9 October 2015

SCEGCS
Redlands Limited
C/- Bloompark Consulting Pty Ltd
Suite 2.02/41 McLaren St
NORTH SYDNEY NSW 2060

Urban Design Outcomes Letter – Master Plan for SCEGCS Redlands Senior School Campus at 272 Military Road, Cremorne – SSD 6454

# WESTERN ELEVATION (1)

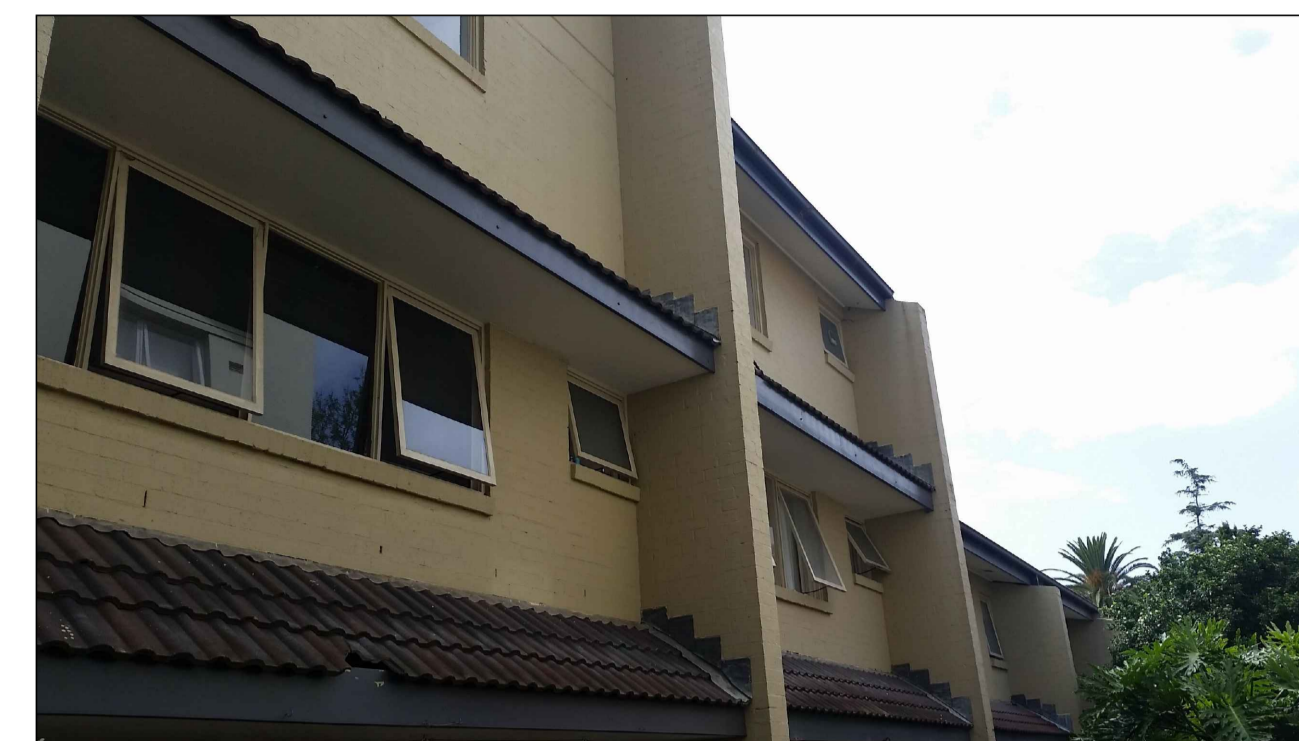
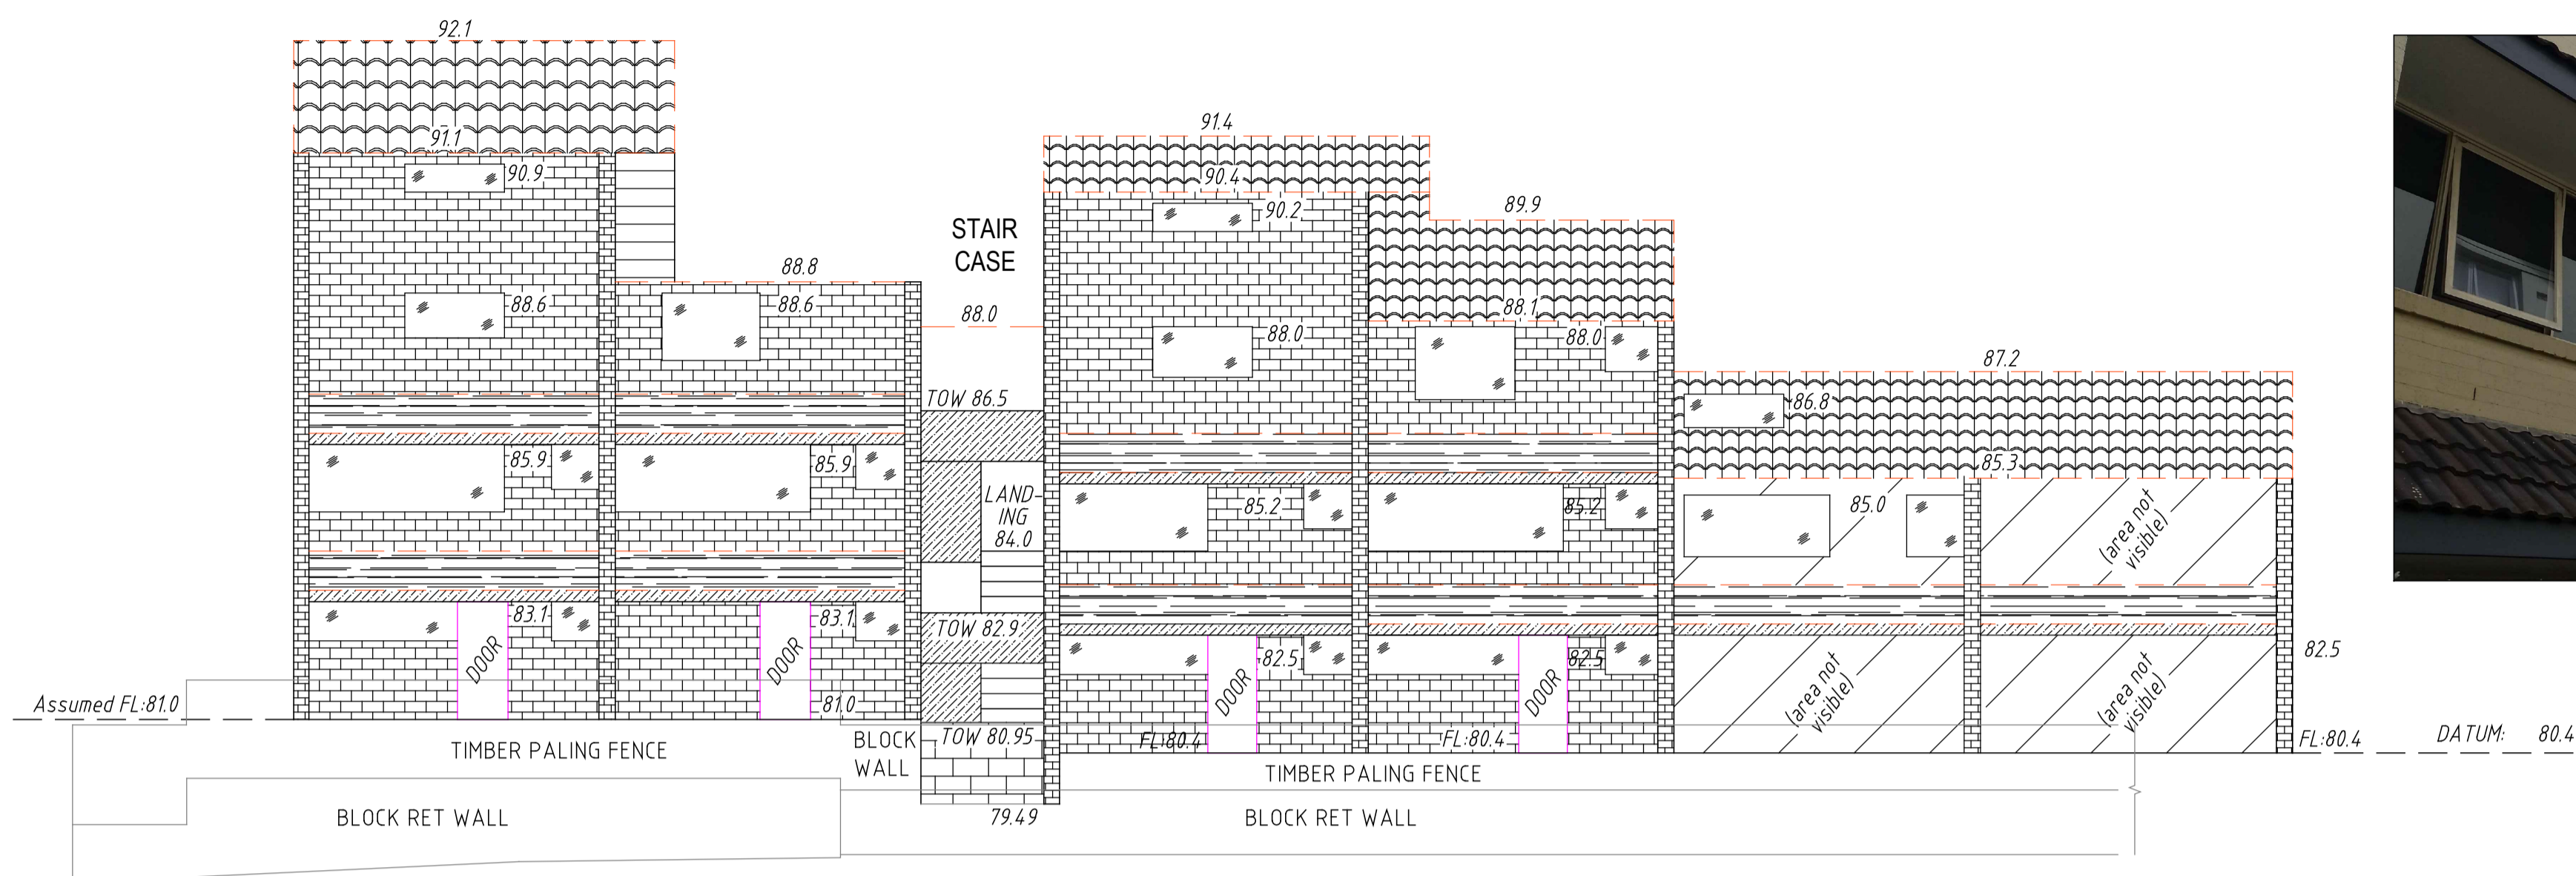
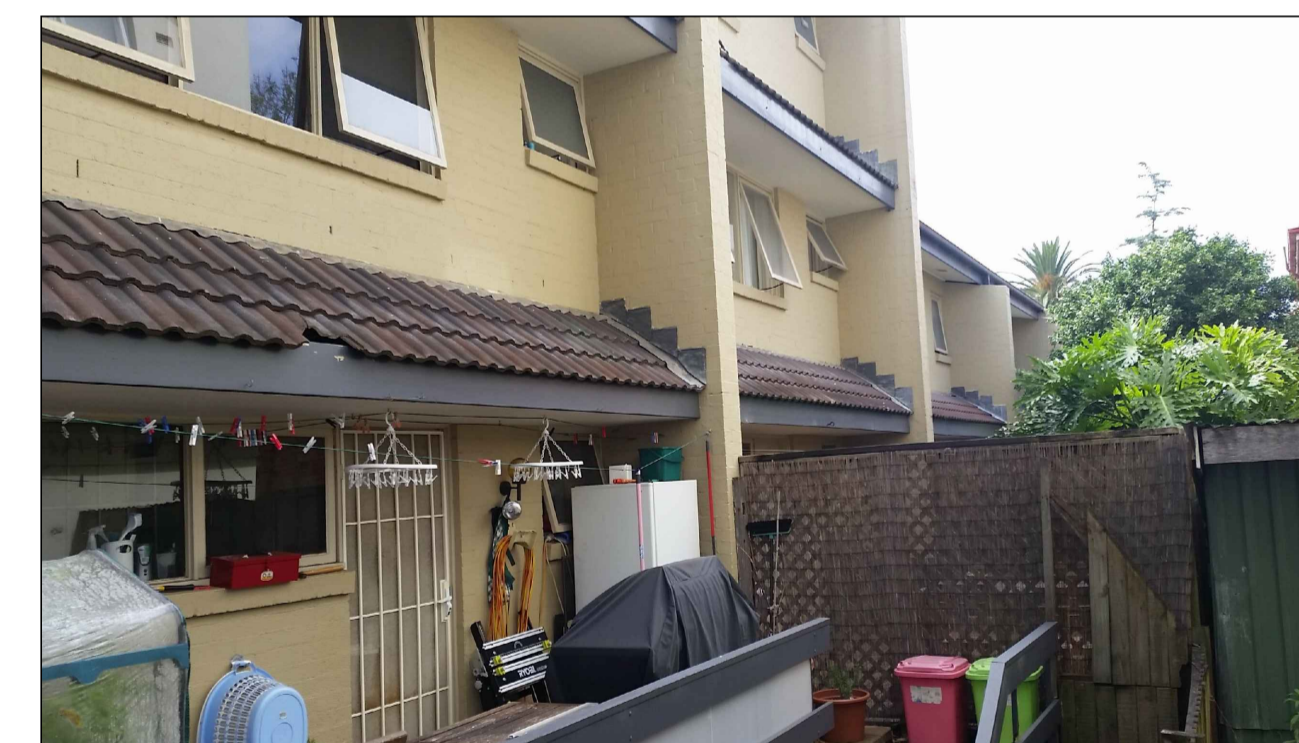
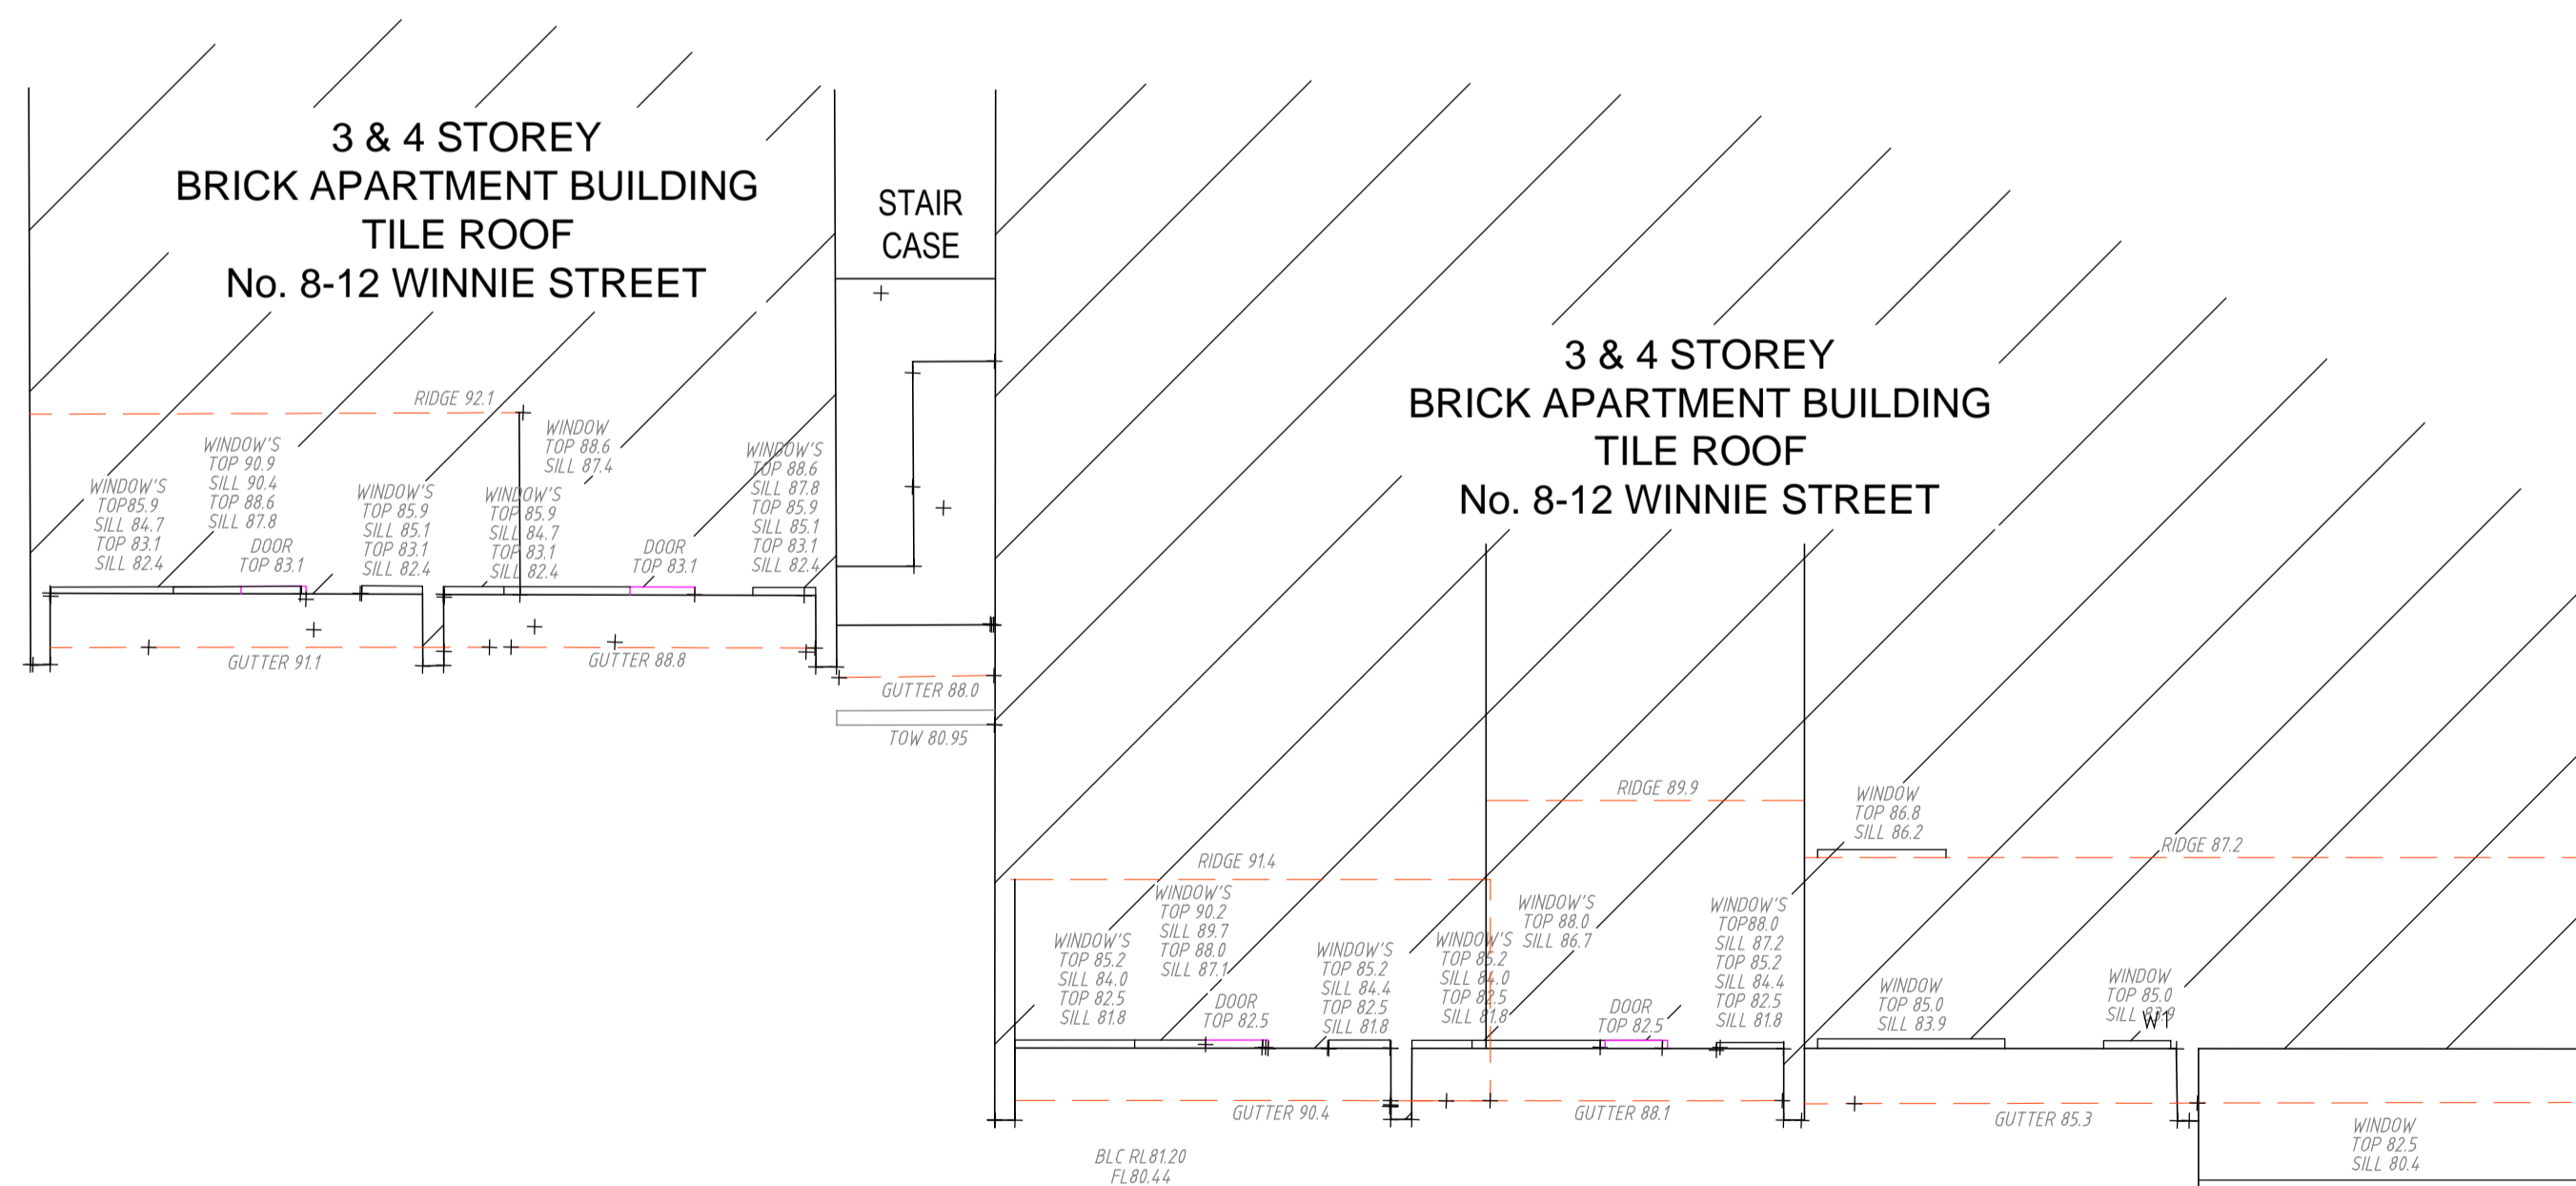
- Consider lighter façade treatment to east elevation to 8-12 Winnie Street apartment building. The proposed east elevation façade as lodged with DPE presents a large wall with a dark façade treatment. Given its northern exposure this dark treatment could make the space between the existing residential building and the proposed school building unnecessarily warm in the summer and dark in the winter. A lighter façade treatment combined with deciduous green wall would help to soften and cool this space in the summer months and brighten it in the winter months.
